CITY OF PORTLAND, MAINE

February 3rd, 2014

Project Name: "118 on Munjoy Hill" Condominium
12 unit residential, and 2 unit commercial, condominium
Project ID: #2013-255
Project Address: 118 Congress Street
CBL: 16-D-2
Applicant: Ed Theriault, EMT, LLC (118 Condominiums, LLC)
Planner: Jean Fraser

LANDSCAPE PLAN
SCALE: 1" = 8'-0"

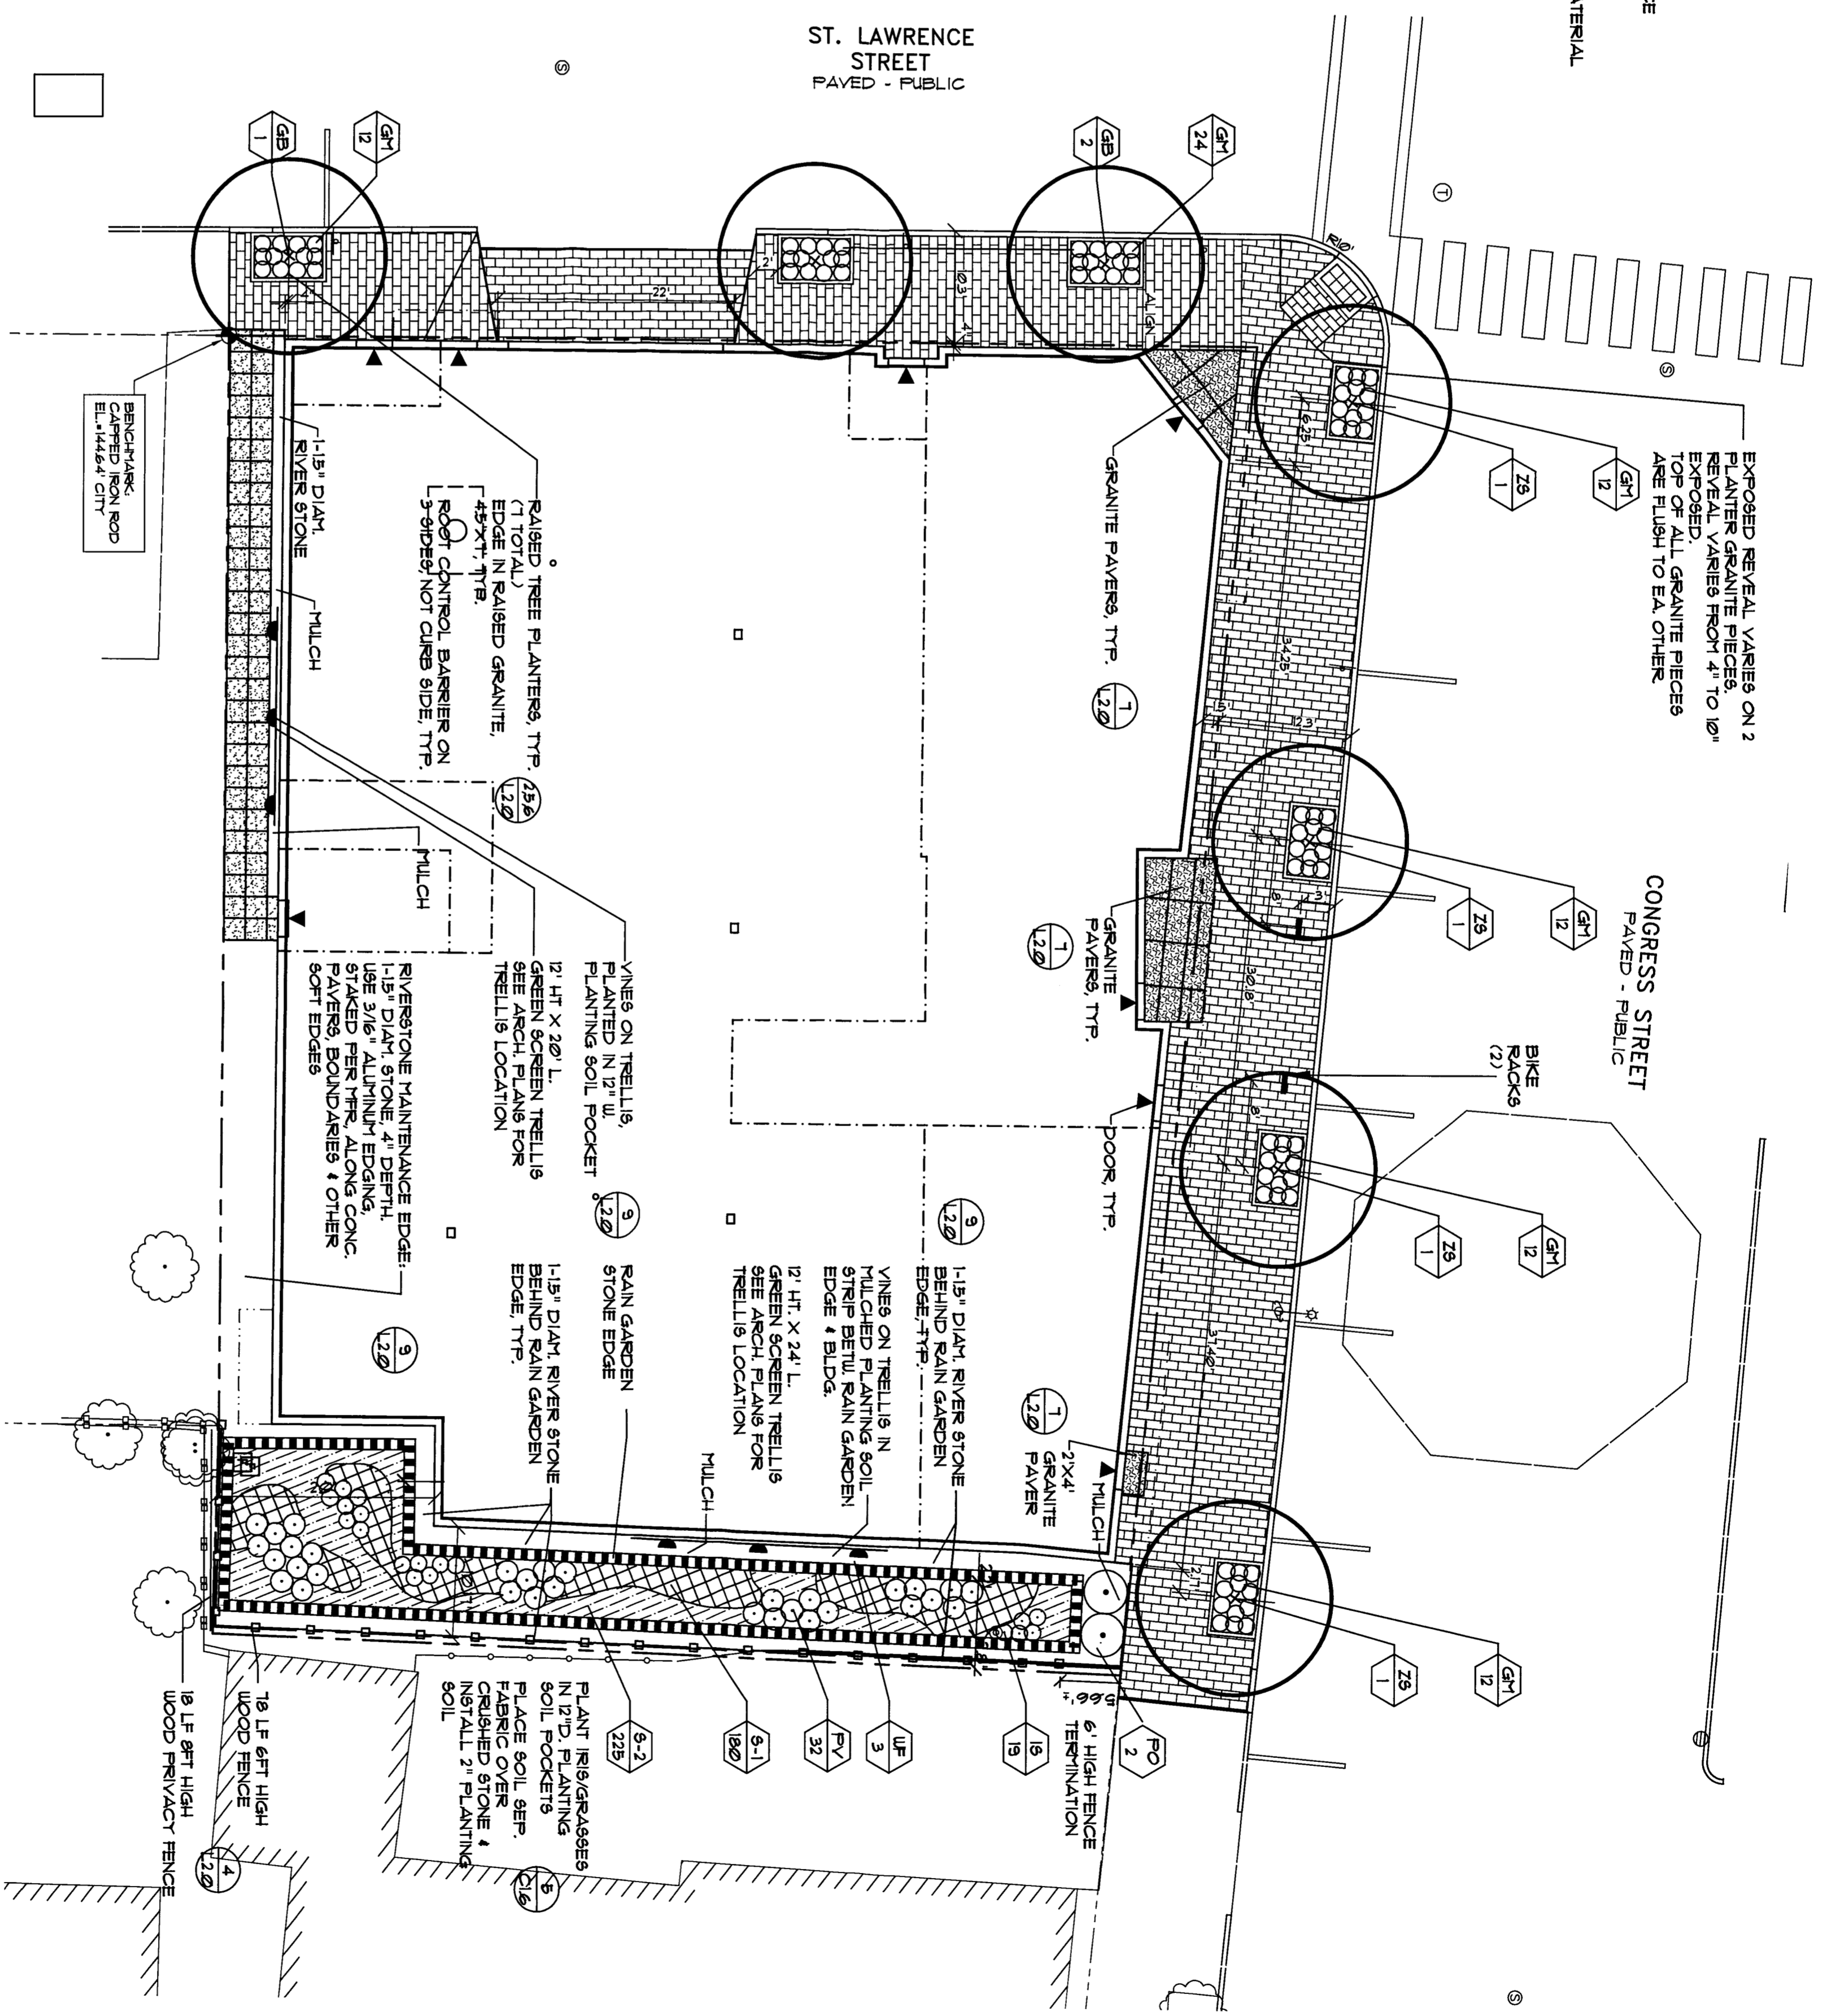
a) Street-trees - the project proposes to plant (6) street trees, (4) along Congress Street, 'save' the existing Pin Oak and plant (2) new on Saint Lawrence Street. Updated plan shows the trees planted in raised granite tree wells with herbaceous planting. If on-street parking is proposed, the tree spacing or setback away from the curb to prevent the opening of car doors is important. The trees can be placed to match the in-between on-street parking, making sure there is good access to the sidewalk from parked cars. The residential tree standard of one tree per unit would also be a condition. Building overhangs over the public way should be discouraged to allow the street tree growth.

Tree types - It would be ideal if the tree types along Congress Street are all the same species. I would recommend the Columnar 'Musashino' Zelkova to be ideal due to the narrow space. See <http://www.jfschmidt.com/articles/musashino> and photo below.

The 'Red Sunset' Maple crown shape is too broad for this space. Along Saint Lawrence Street again a more narrow tree is needed, it could be Ginkgo 'Magyar' or 'Autumn Gold' cultivar (seedless), due to narrow sidewalk space. (photo 'Musashino' Zelkova, narrow vase shape crown)

b) Landscape - The recent revision adds herbaceous planting to the tree planters and the 'backyard' / rain-garden edge. Additional screening to the adjacent property should be considered, this might be achieved by adding higher branching landscape planting or higher fencing (5'). The rain-garden planting with mostly herbaceous plant material will reach a low height. It does not appear to meet the B-1 Zone landscape standard (i) " A densely planted buffer and / or fencing will be required to protect neighboring properties..." Suggestions could including some taller shrub plants along with a higher wooden fence. The Green Wall proposed will also help screen the building. Additional green-wall / landscape planting could be used on the West elevation to the left of the garage door, this area seems blank; and to the left of the center door on Congress Street away from the overhead canopy.

Granite planters in right of way - the six granite planters are proposed to be planted with street-trees and 'Cranesbill', perennial geranium. This will add interest to the typical mulched tree well. Long term however it is unlikely the city would be able to maintain these plantings. Ideally, the project could adopt the tree wells and maintain the landscape planting.

- vi. That the applicant shall submit a revised Landscape Improvement Plan to address the City Arborist comments of 1.22.2014 in respect of the site landscape (buffering and additional trellis), to also address CPTED principles as relevant, for review and approval by the Planning Authority and City Arborist prior to the issuance of a building permit; and

1 NORTH ELEVATION
1/8" = 1'-0"

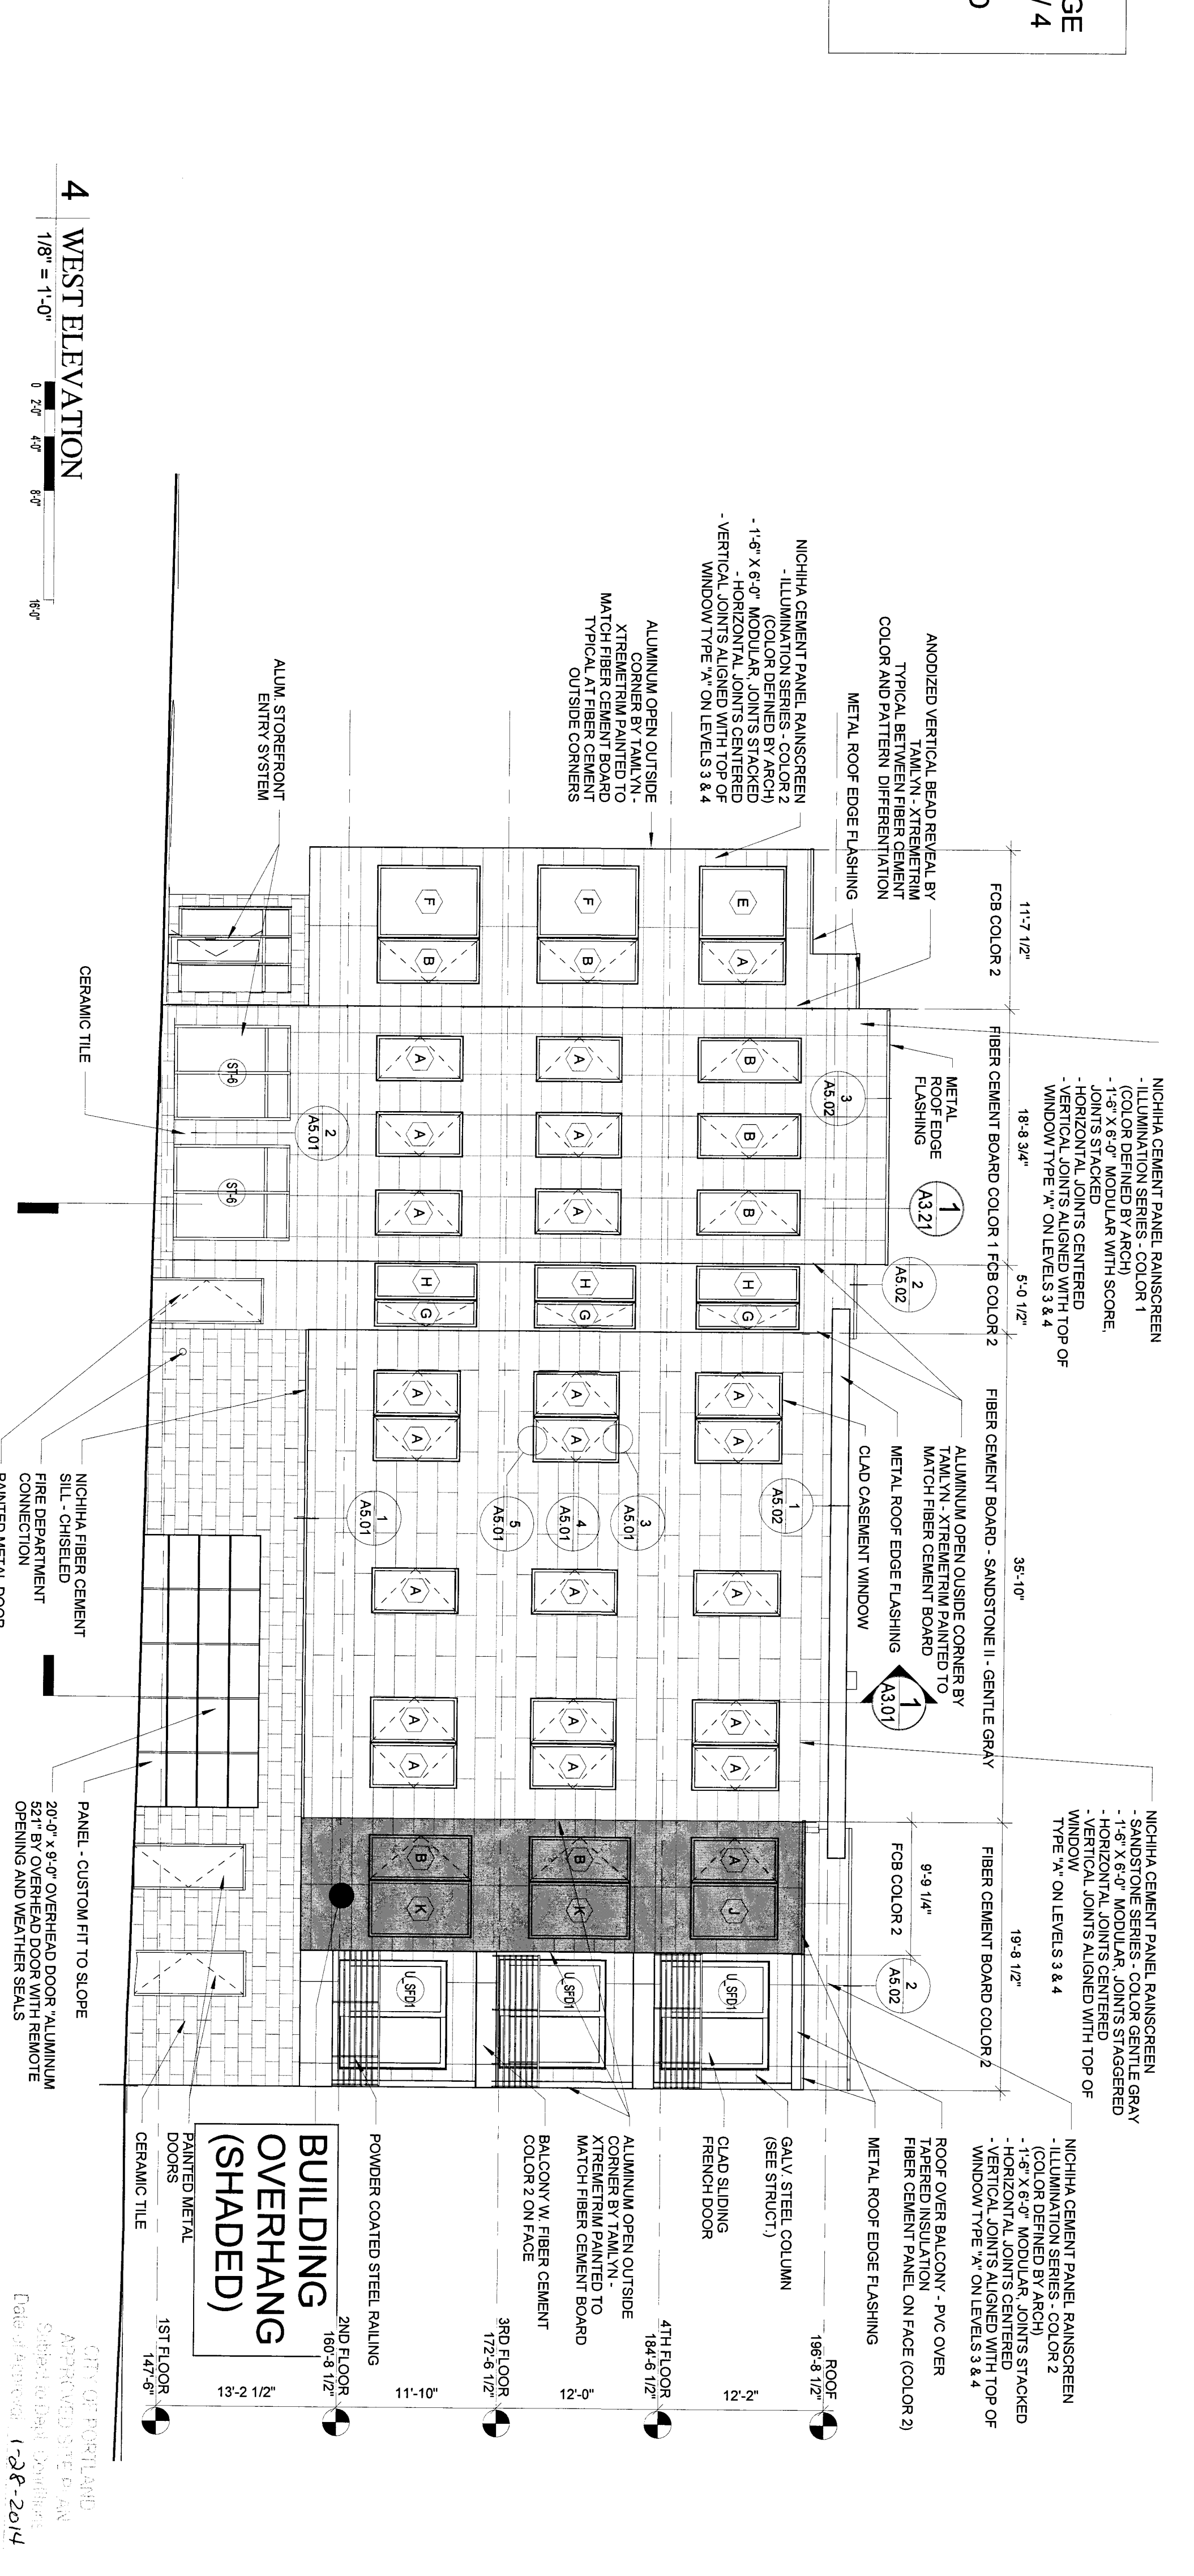
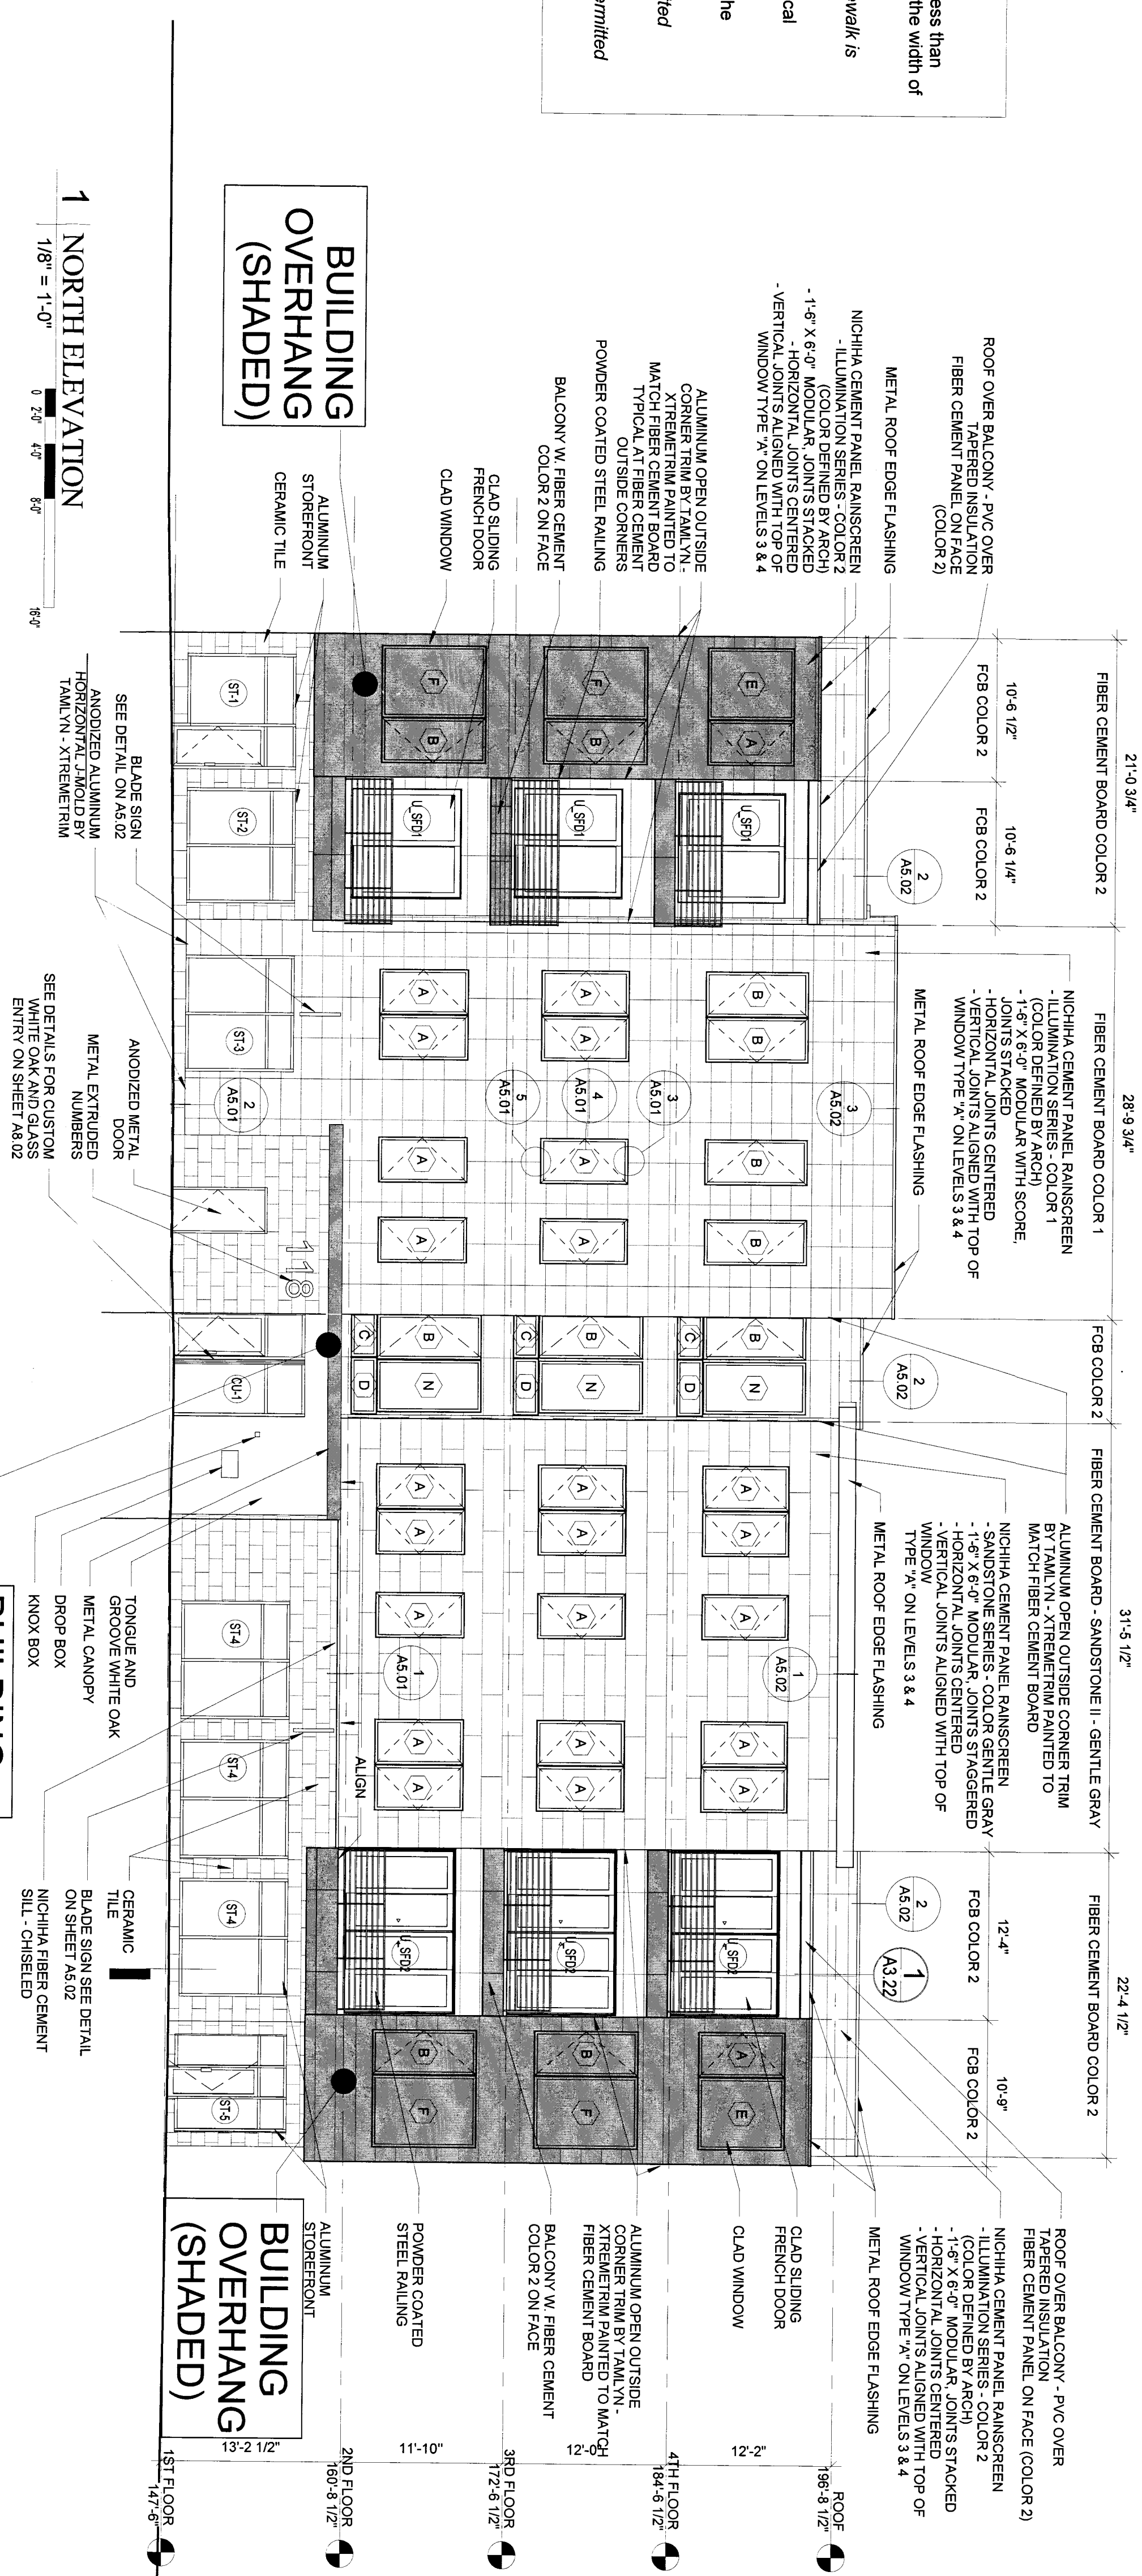
- i. The applicant shall submit a revised building design that results in the decks on St Lawrence Street being within the property boundaries while maintaining the current quality of design in regards to facade articulation and variation of form, for review and approval by the Planning Authority prior to signing of the Subdivision Plat; and

The Planning Board, in considering this project, were aware that the associated building projections (including decks) over the ROW would need a license to be approved by the City Council and that there were staff concerns about this aspect of the project. The Planning Board voted 5-2 (Dean and Hall opposed) to send a Communication to the City Council outlining the basis of the Board's support for the projections on this particular project.
